Subject: Planning ref: 19/02948/F. Land to the South of and Adjacent to South Side Steeple Aston.

The comments above are made on behalf of Thames Valley Police and relate to crime prevention design only. I hope that you find them of assistance in determining the application and if you or the applicants have any queries relating to crime prevention design in the meantime, please do not hesitate to contact me.

Crime Prevention Design Advisor | Oxfordshire | Local Policing | Thames Valley Police

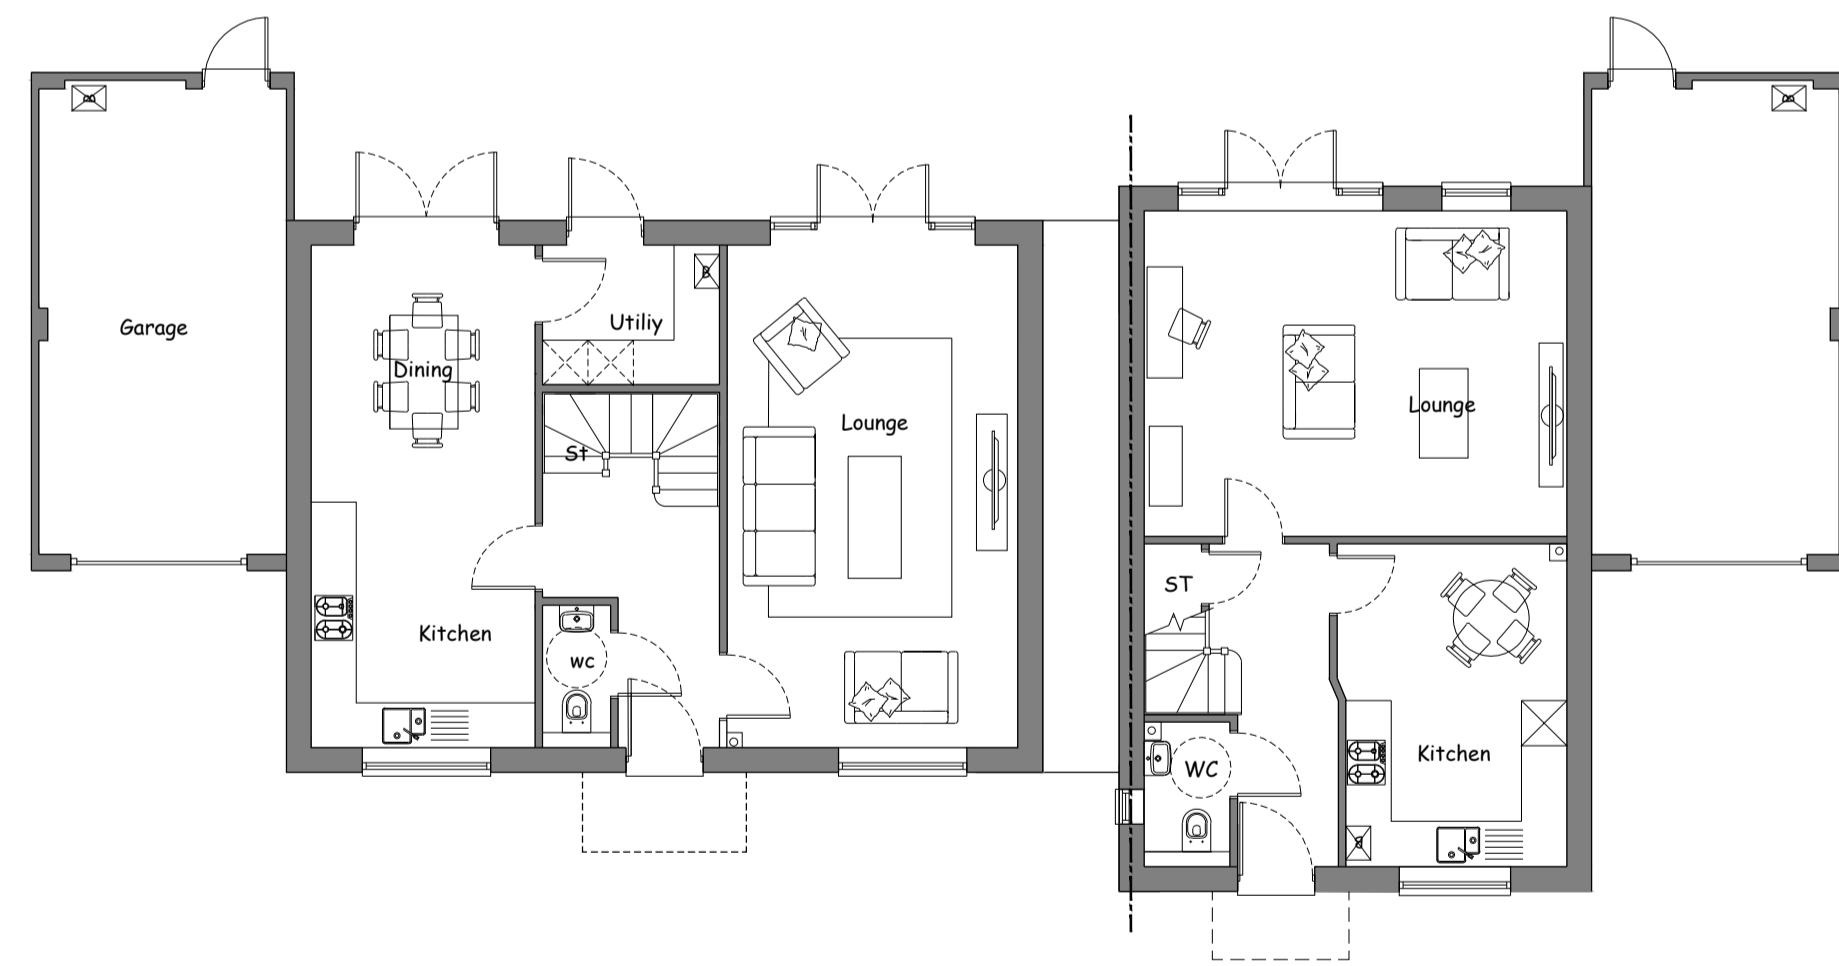
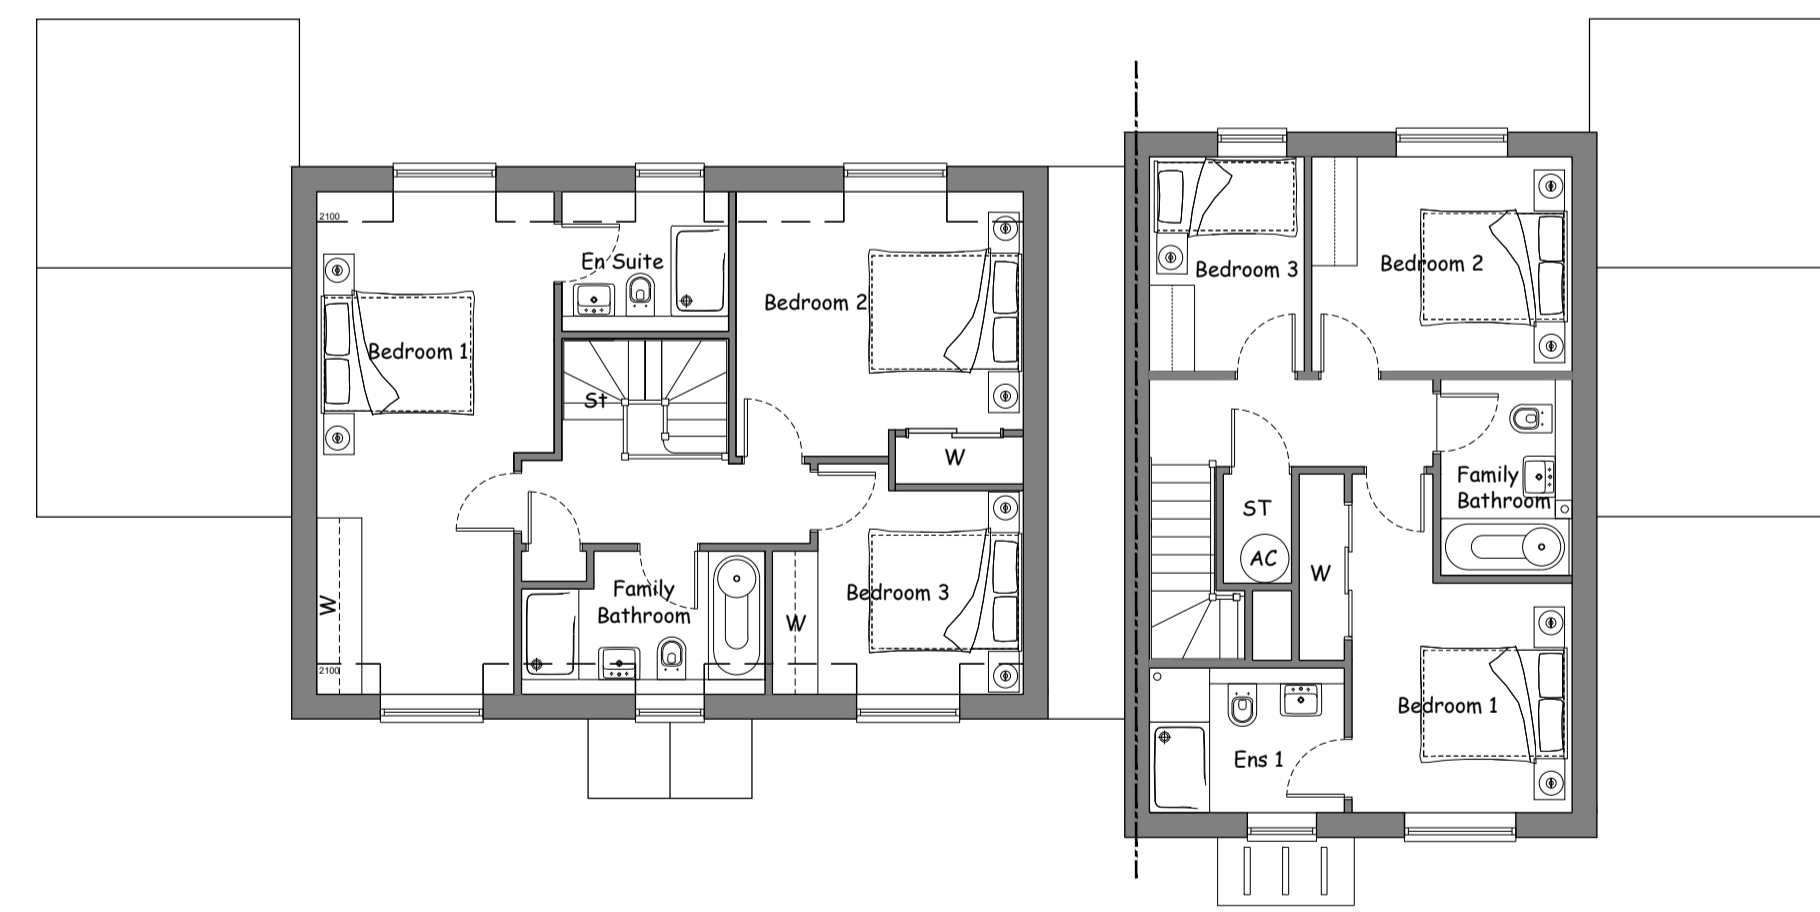
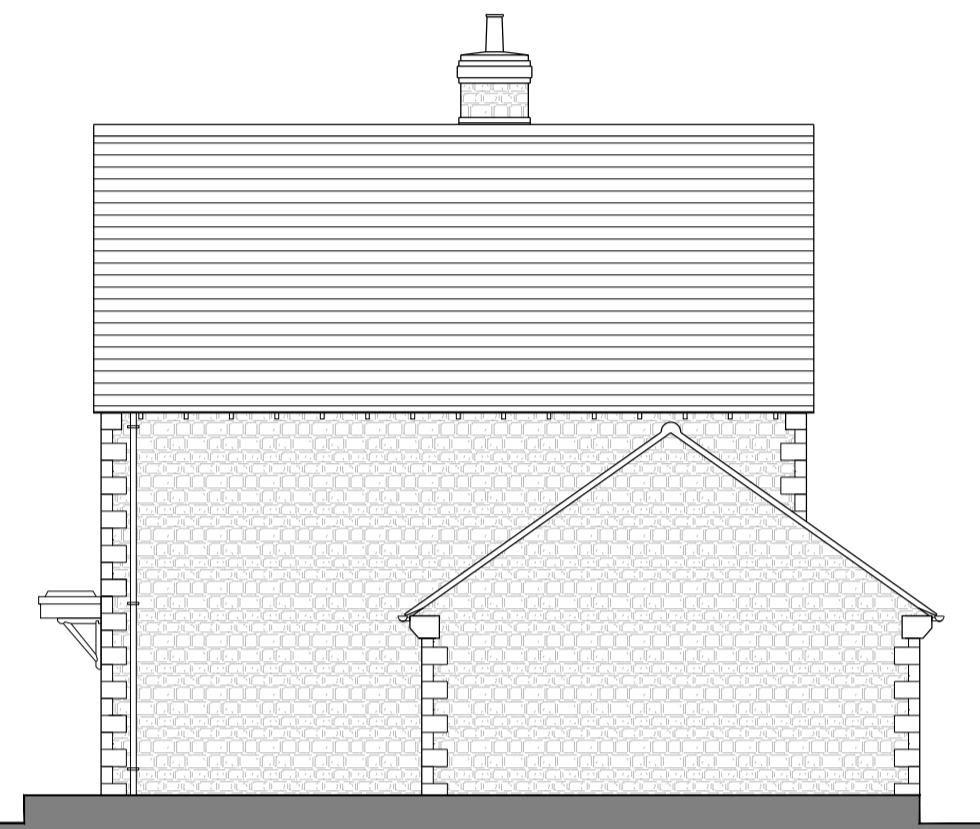
- All access gates to rear gardens should be; robust, of the same height as boundary treatments, self-closing, have anti-lift hinges and be key operated from both sides. I note that some are not positioned as close to the front building line as possible. This creates problematic recesses/hiding places. This should be rectified wherever possible. In addition,

there is now covered passageway between plots 6 and 7 which also requires gating for the same reasons.
